30 Merrill Conditions of Site Plan Approval

Mon, Nov 28, 2016 at 2:01 PM

I've reviewed the updated plans, and can provide the following comments. Tom will need to weigh in on a couple of them.

3 EXTERIOR TREAD/RISER DETAIL
SCALE: 1-1/2" = 1'-0"

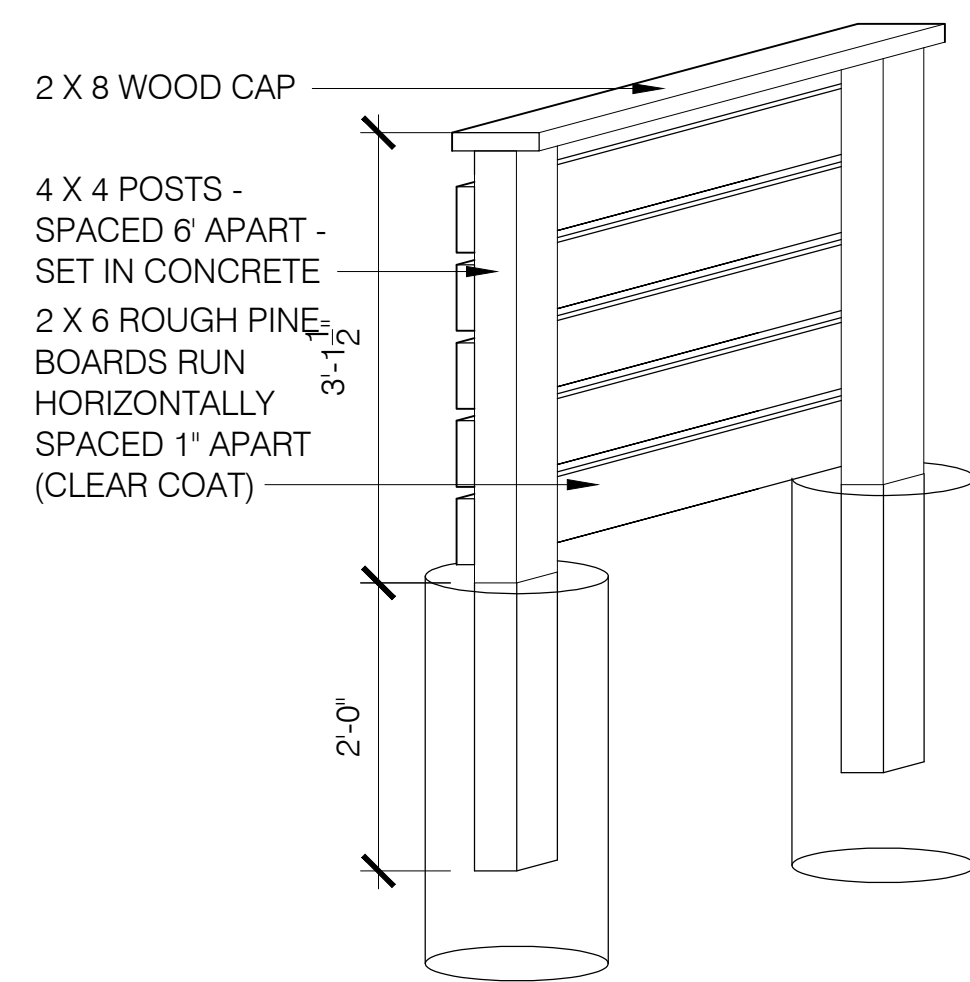
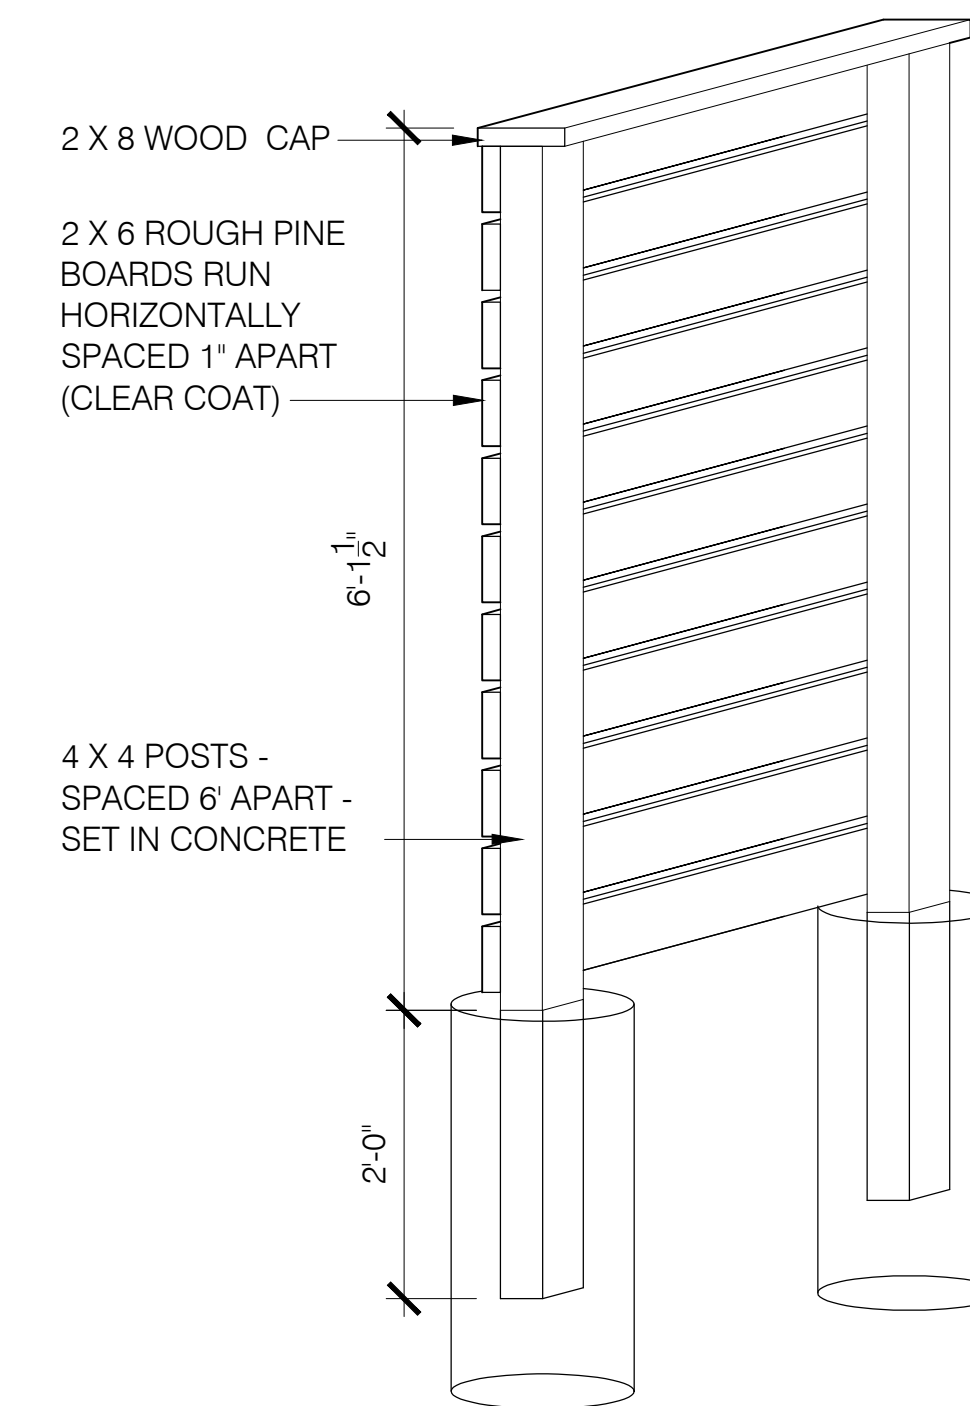
1.c. The site plan includes a couple of lines at the front entrance that could represent steps, but they are not labeled, and the grading plan does not reflect steps. They do show concrete planters around the front of the building that may also be the benches that are referred to. The architectural details include two different stair riser/tread details. These are both more extensive than would be at this front step though. Based on the renderings, it looks like these will be just granite steps. More information on what we're looking at would be helpful here.

13 FENCE DETAIL NEAR CURB
SCALE: 3/4" = 1'-0"

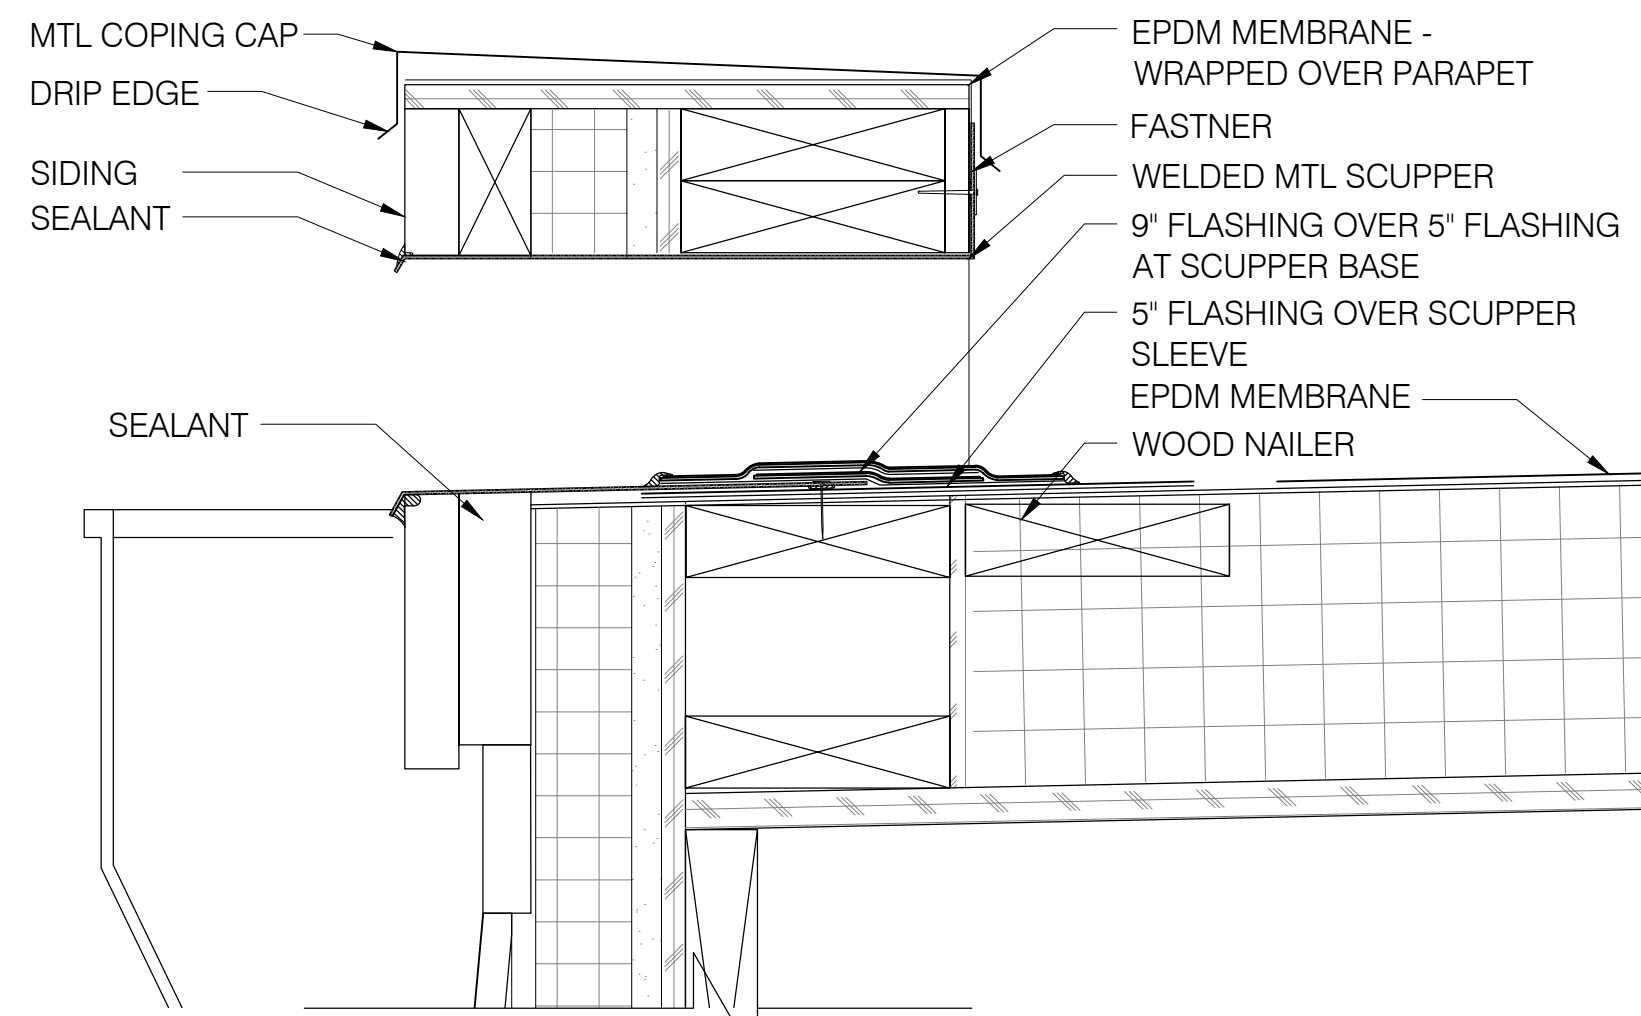
1.b. They are showing a 3'-1.5" fence for the final 10 feet of the driveway prior to the sidewalk. I believe that vertical sight distance is typically calculated considering a 3.5' eye height, so it seems like that should work, considering that grade is sloping down towards the sidewalk. Looking at the site, it's interesting to note that the property to the northwest has wood fence, but switched to chain link for the last few sections leading out to the sidewalk. This provides visibility of the sidewalk. I'm sure that's not the look they are going for here though. Tom may have some additional thoughts on this one.
